Addendum No. 2

RE: Contract # C204507

Cumberland County (U-5798A)

SR-1102 FROM NORTH OF SR-1112 TO US-401 AND REPLACE BRIDGE
250075 OVER LITTLE ROCKFISH CREEK.

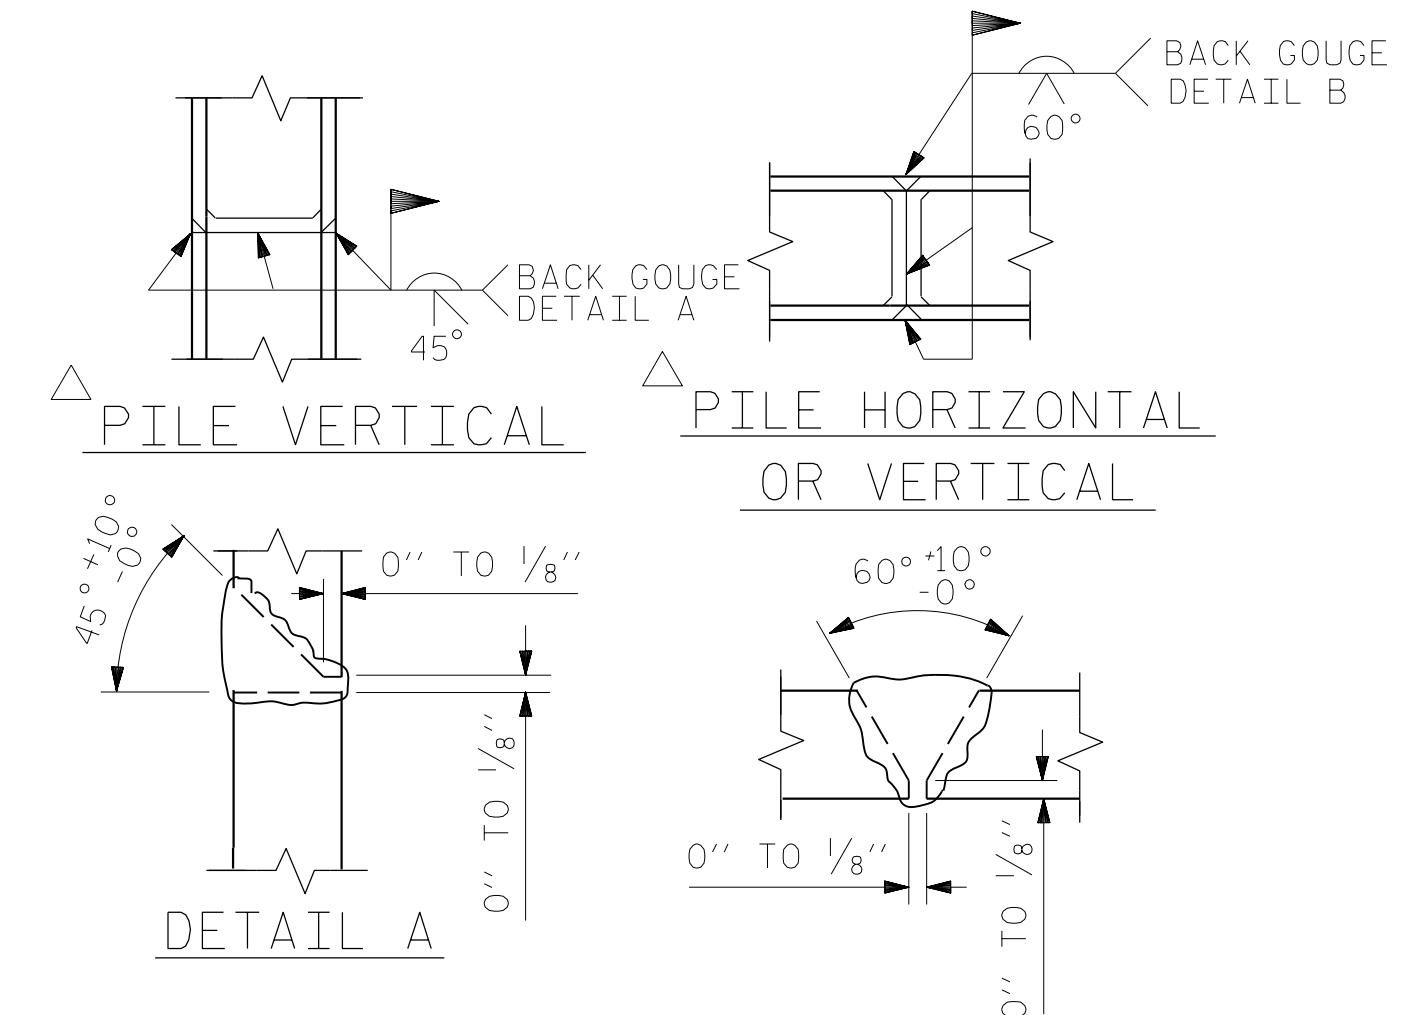
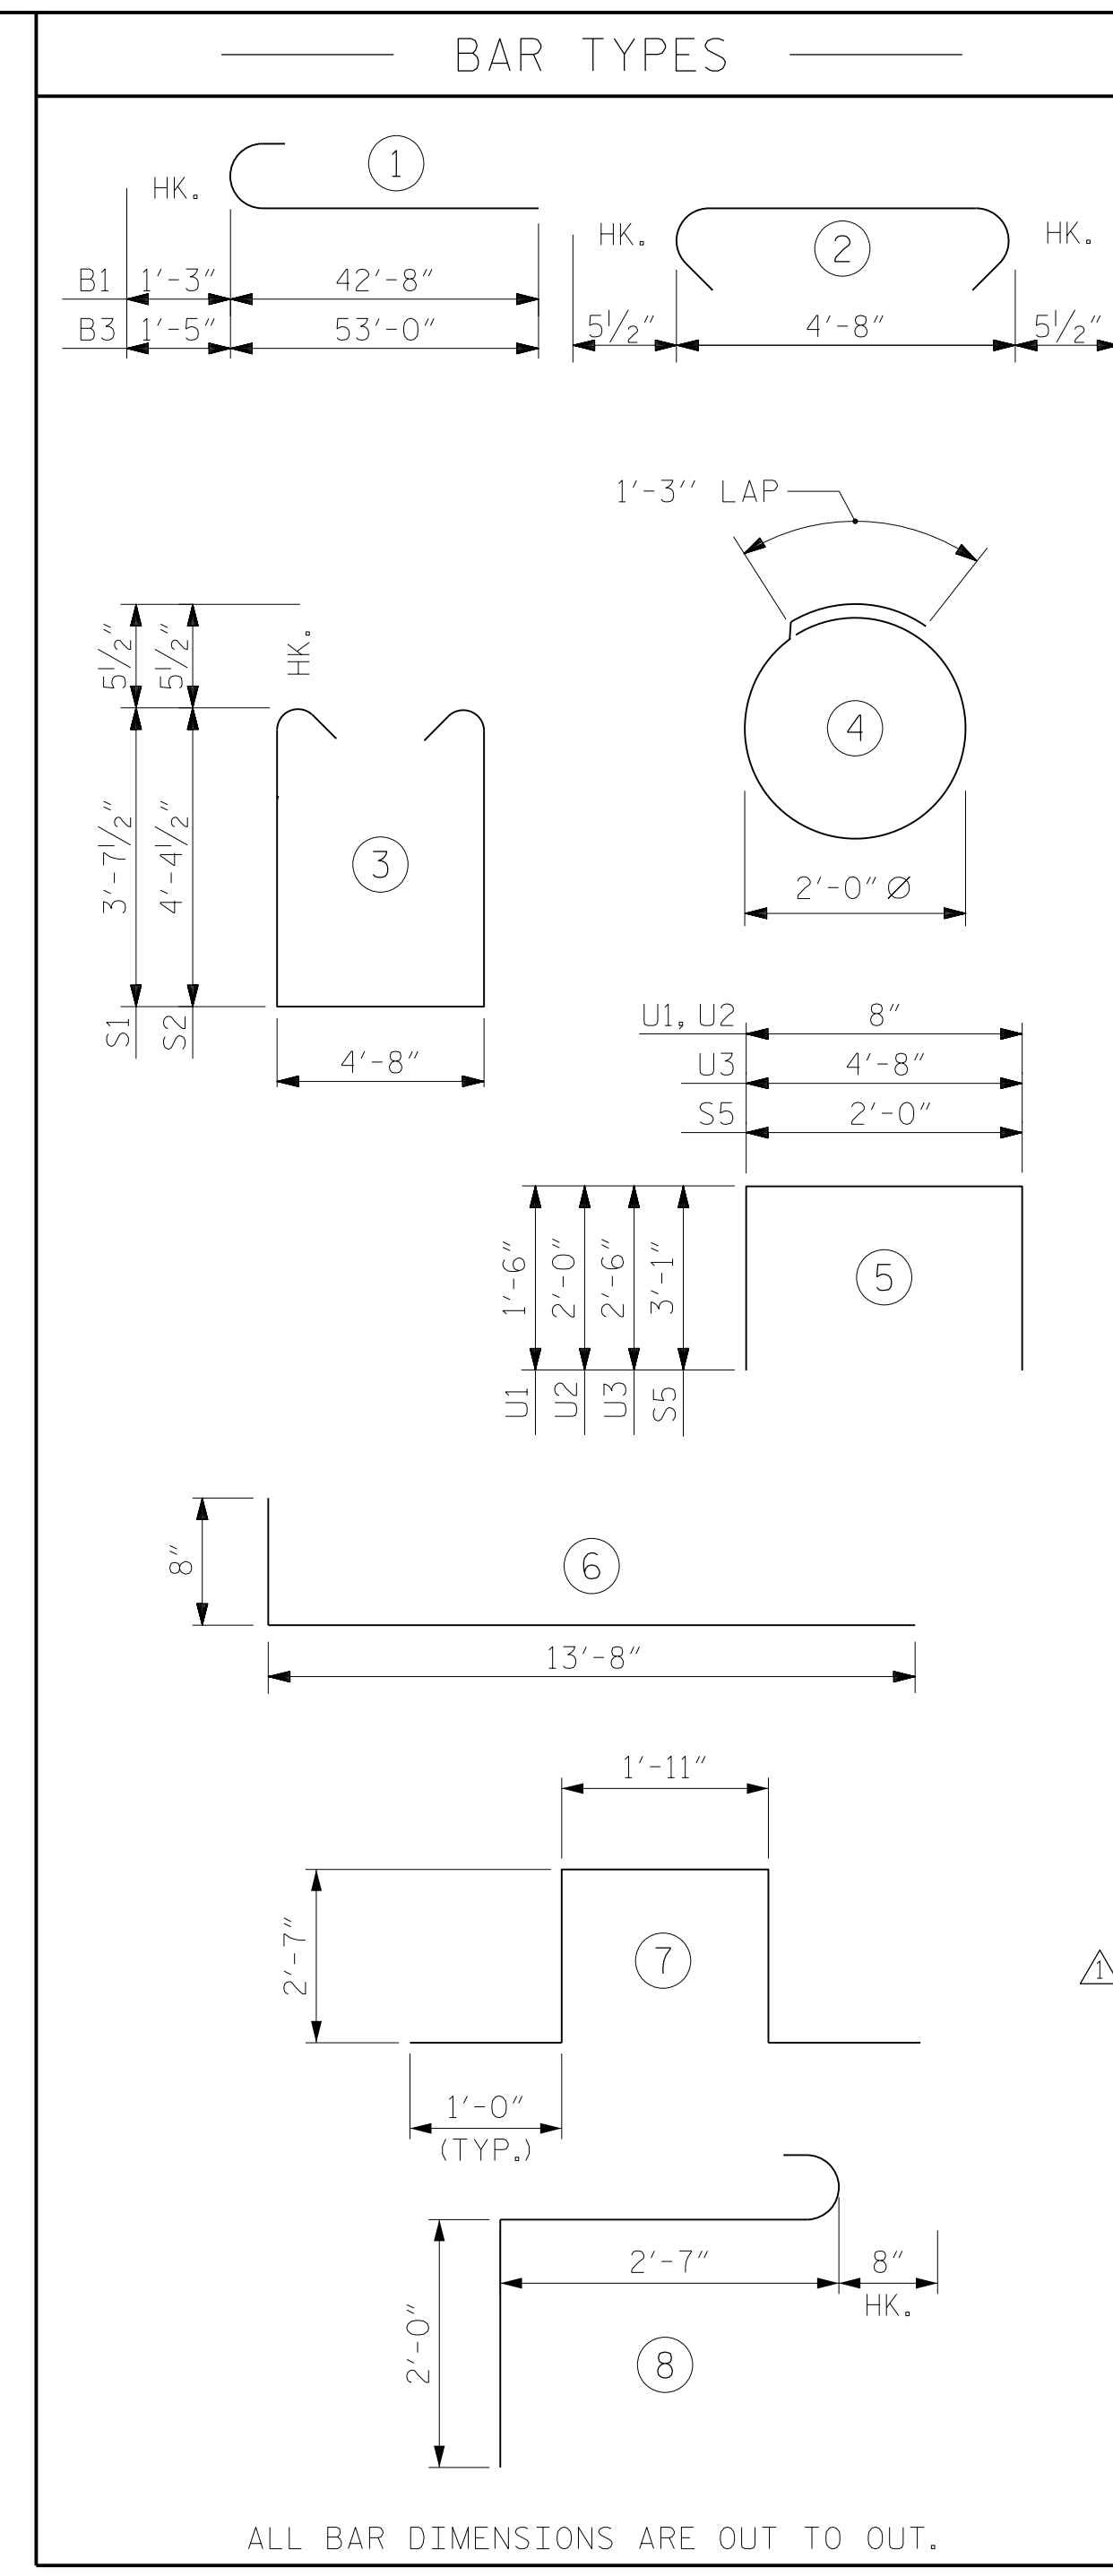
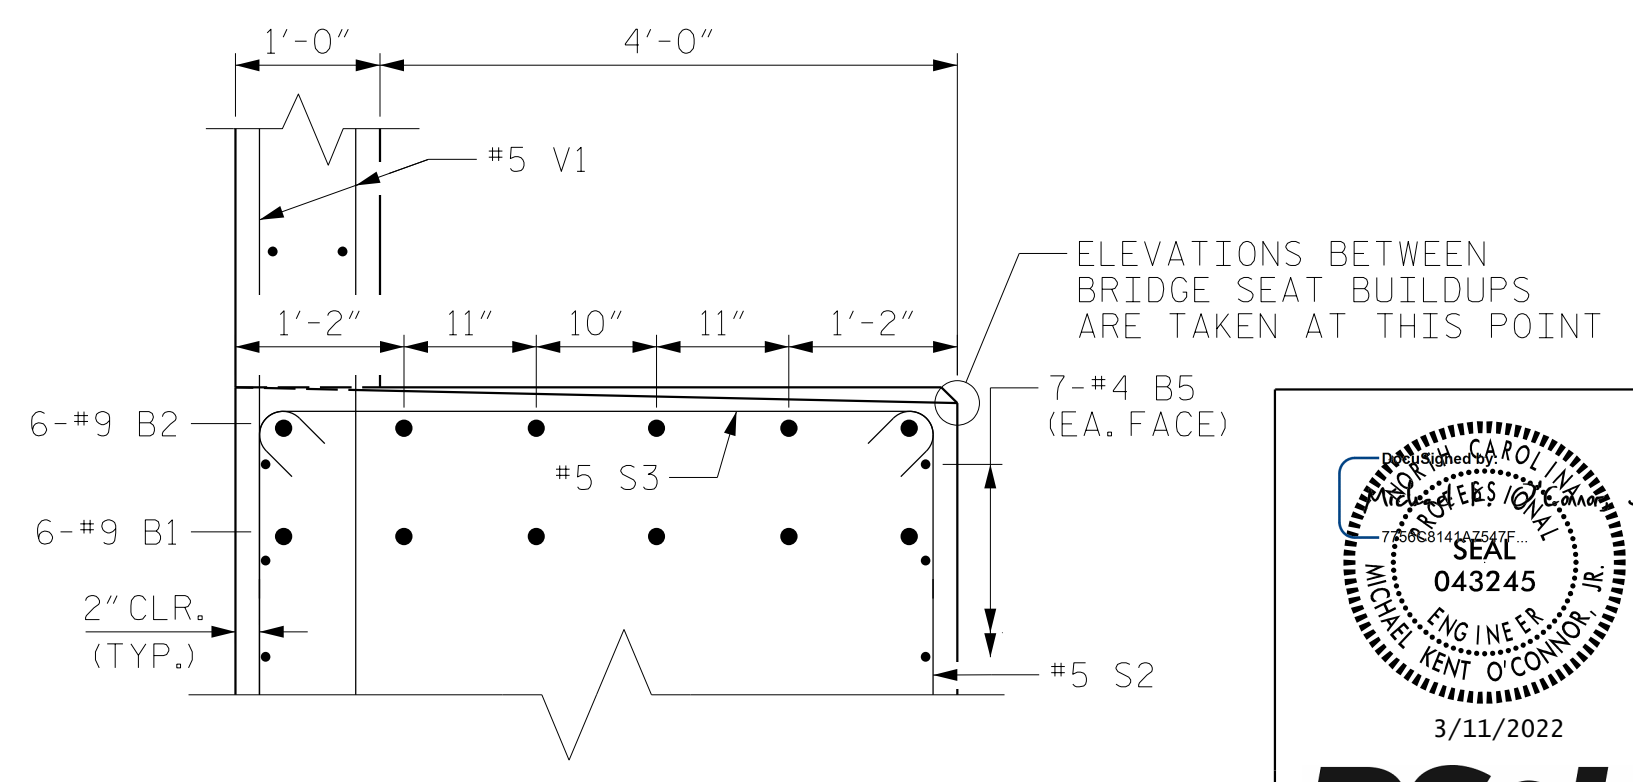
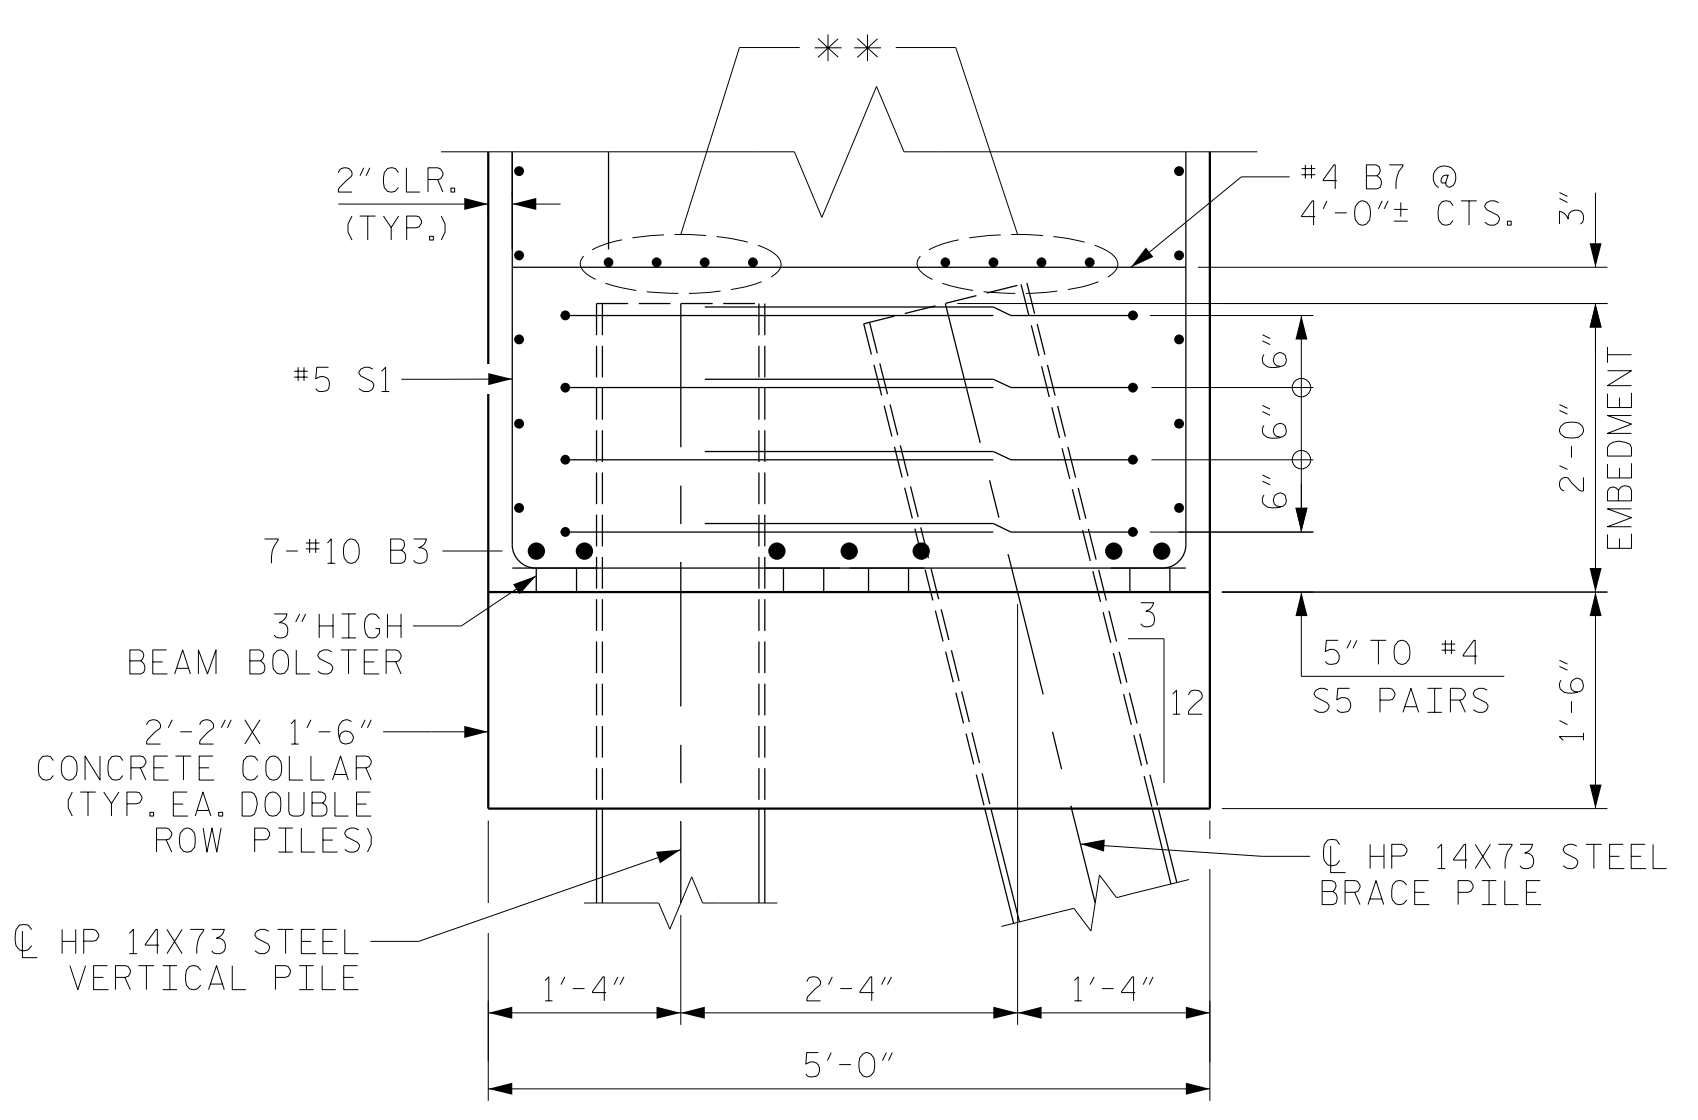
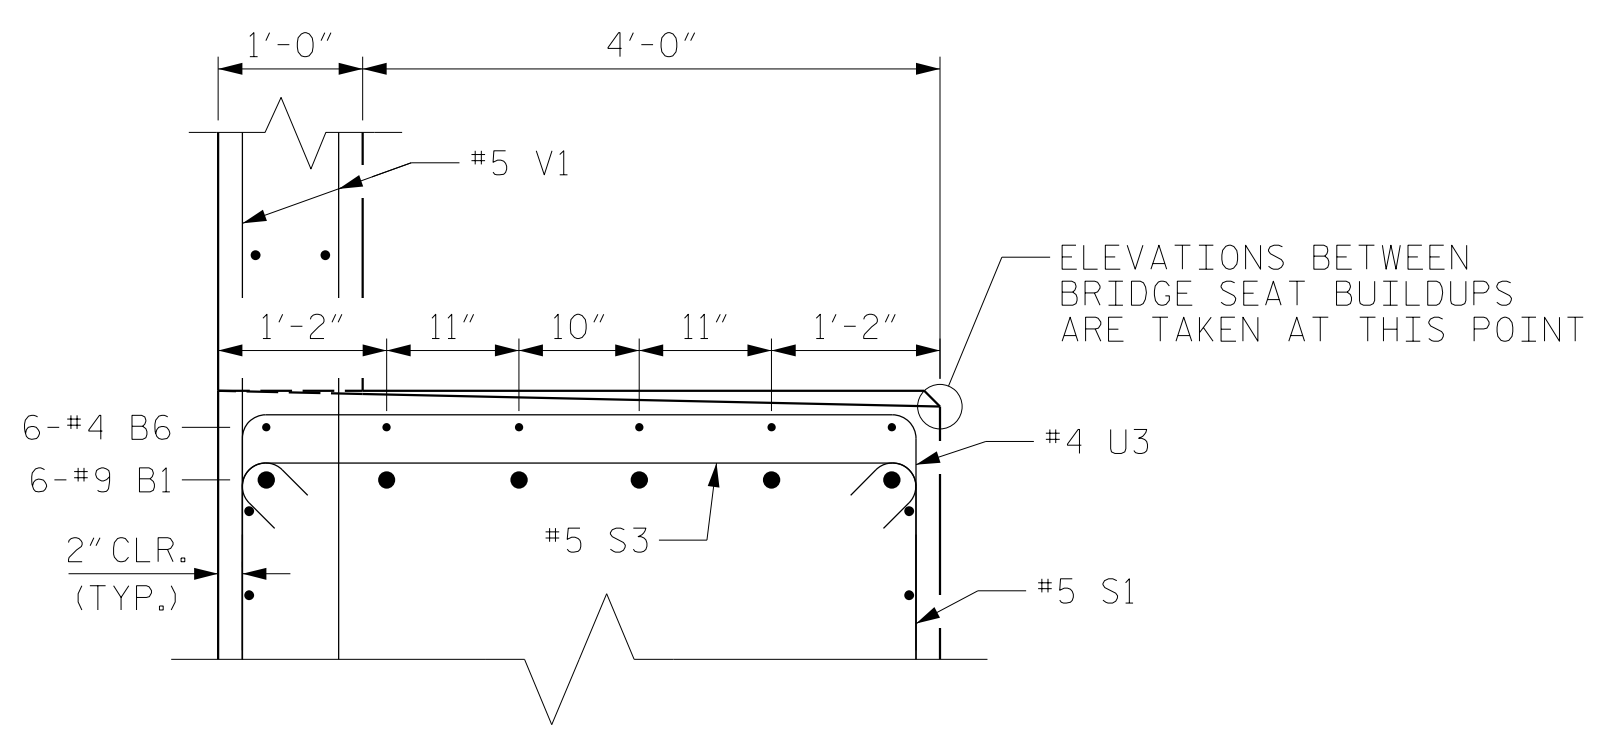
Sheet No.	Revision
S1-3	Updated to reflect quantity changes.
S1-33	Updated to reflect quantity changes.
S1-39	Updated to reflect quantity changes.
S2-3	Updated to reflect quantity changes.
S2-33	Updated to reflect quantity changes.
S2-39	Updated to reflect quantity changes.

<u>Item</u>	<u>Description</u>	<u>Old Quantity</u>	<u>New Quantity</u>
0240-8328200000-E-450	PILE DRIVING EQUIPMENT SETUP FOR HP 14 X 73 STEEL PILES	40 EA	44 EA
0242-8384000000-E-450	HP 14X73 STEEL PILES	2,580 LF	2,840 LF
